Further WSCC Highways comments

The LHA requests the applicant provides the following,

Drawing No.	Rev
NJC-001	-

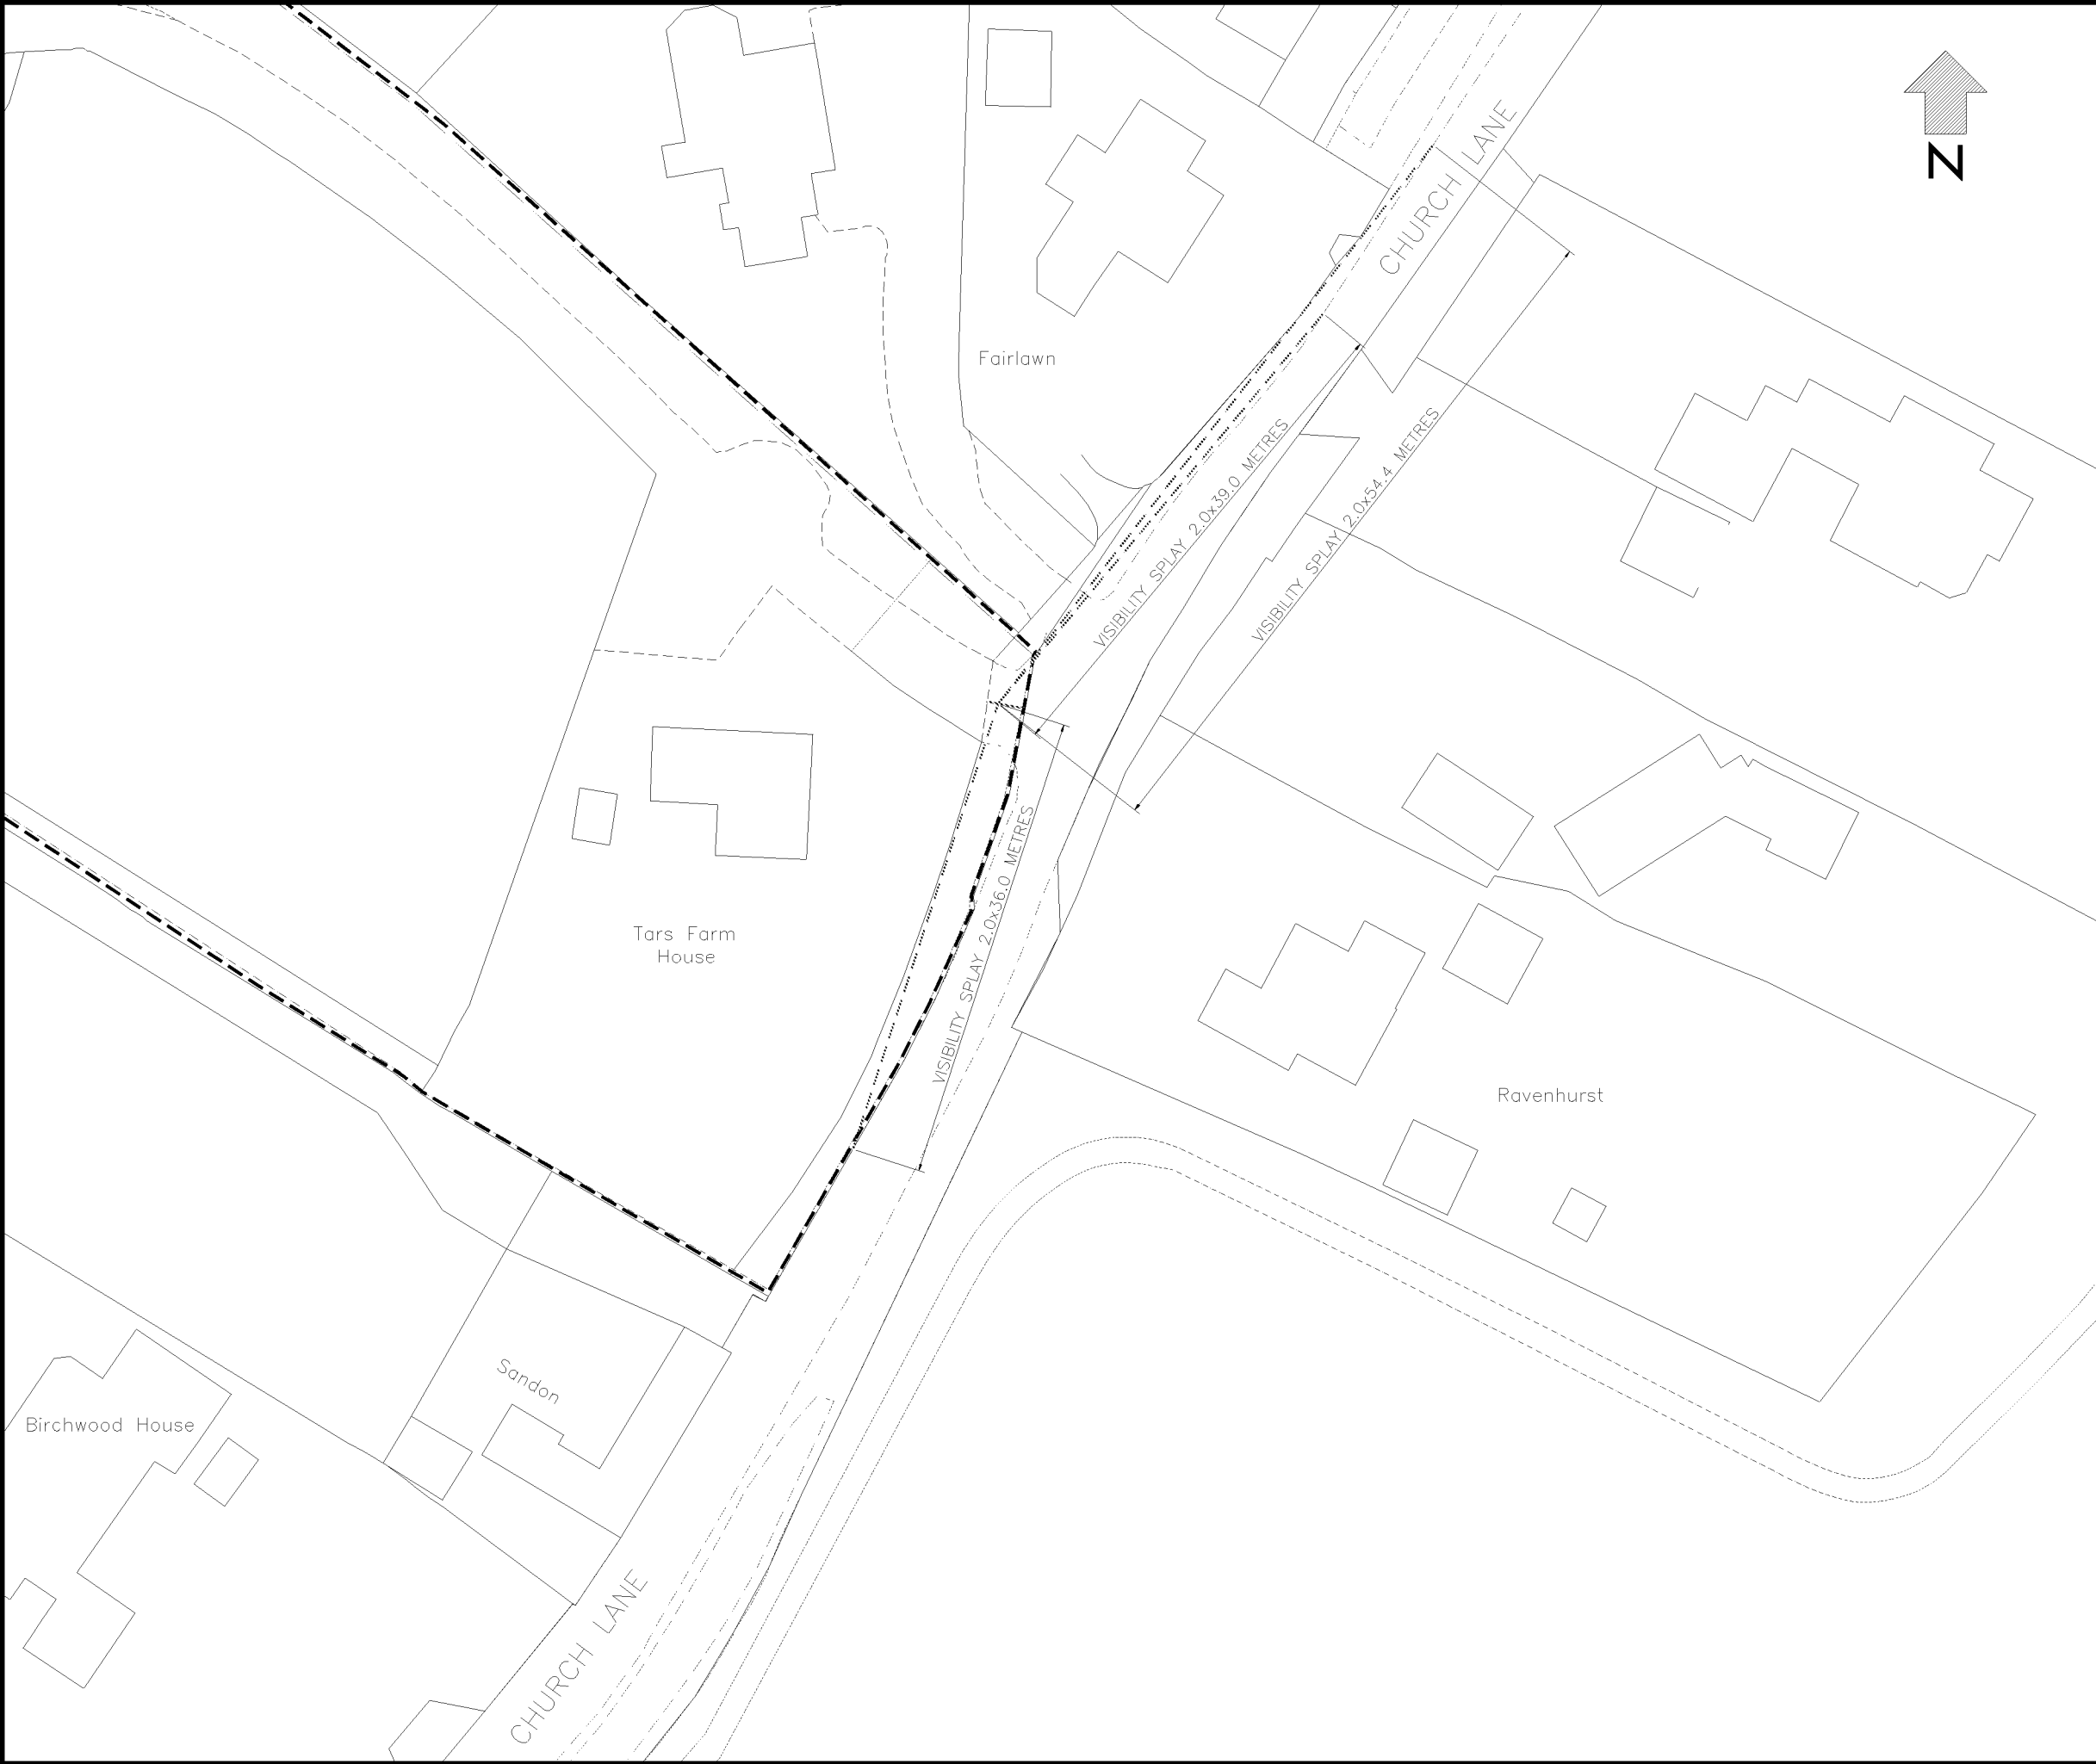
- The Transport Assessment (TA) states the average speed survey data, the LHA requests the applicant provides the full 7 day speed survey data.
- Maximum achievable visibility splays both existing and proposed, these should **only** fall within land under the applicants control or within the publicly maintained highway.
- The kerb radii is below WSCC standards, ordinarily the kerb radii for a bell mouth should be 6 metres and as such the LHA request this is demonstrated.

The resulting kerb radii adjustments may interfere with the telegraph pole in this location, if this is so, the LHA advises the applicant to contact the operator of the pole to discuss relocation works.
